Our reference: 229927

RE: State Significant Development Application SSD-87245208 Response to Submissions at 13-15 & 17 Oxford Street and 2 Verona Street, Paddington

RE: SSD-87245208 at 13-17 Oxford Street and 2 Verona Street, Paddington

a) The Section Plan – Cultural Creative & Courtyard (see page 6) dated 10/04/2026, Drawing No. A 207 provided by TZG shows the location of Busby Bore and curtilage in relation to the proposed basement works.

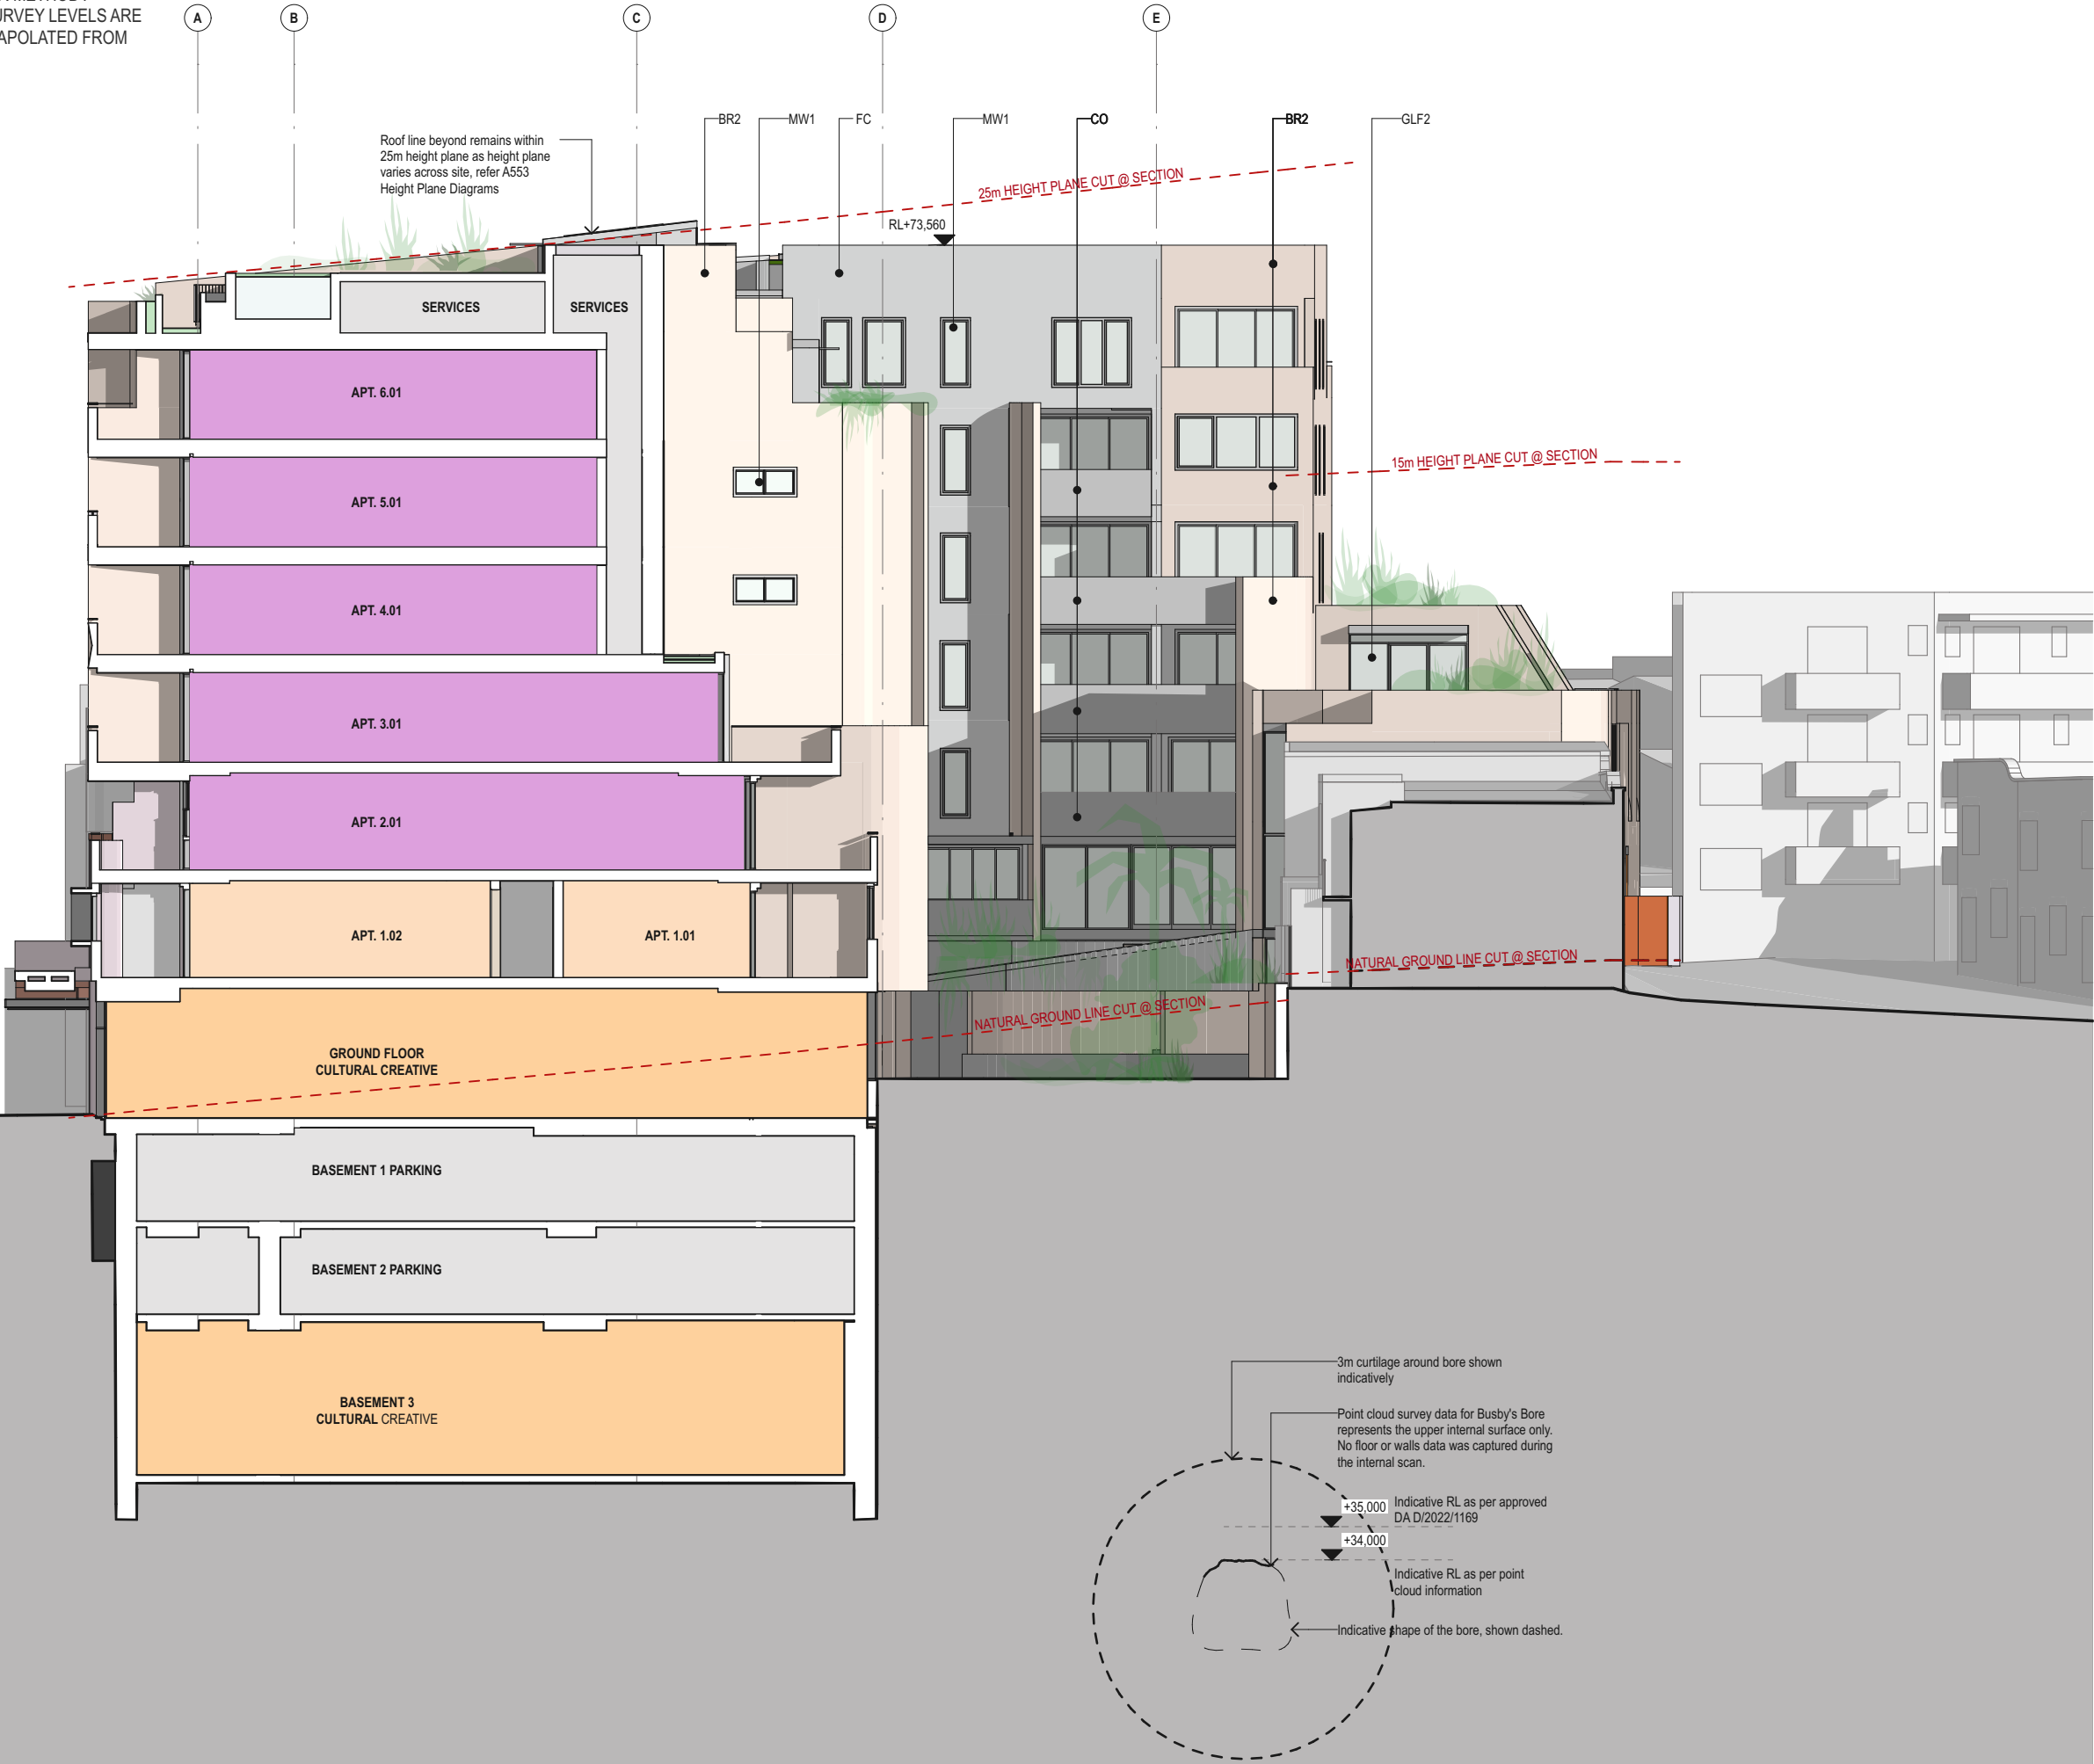
- The proponent should show the location of Busby’s Bore in the Section plans, demonstrating the proposed separation from basement excavation and construction and relative depth compared with the proposed new building basement levels.

- The proponent is required to address the above heritage comments and provide Section plans showing the location of Busby's Bore, demonstrating the proposed separation from basement excavation and construction and relative depth compared with the proposed new building basement levels.
- **The Department is advised to re-refer this SSDA to Sydney Water for review once heritage comments have been addressed.**
- The Department is advised to forward the enclosed Sydney Water Development Application Information Sheet (for proponent) to assist the proponent in progressing their development. This Info Sheet contains details on how to make further applications to Sydney Water and provides more information on Infrastructure Contributions.
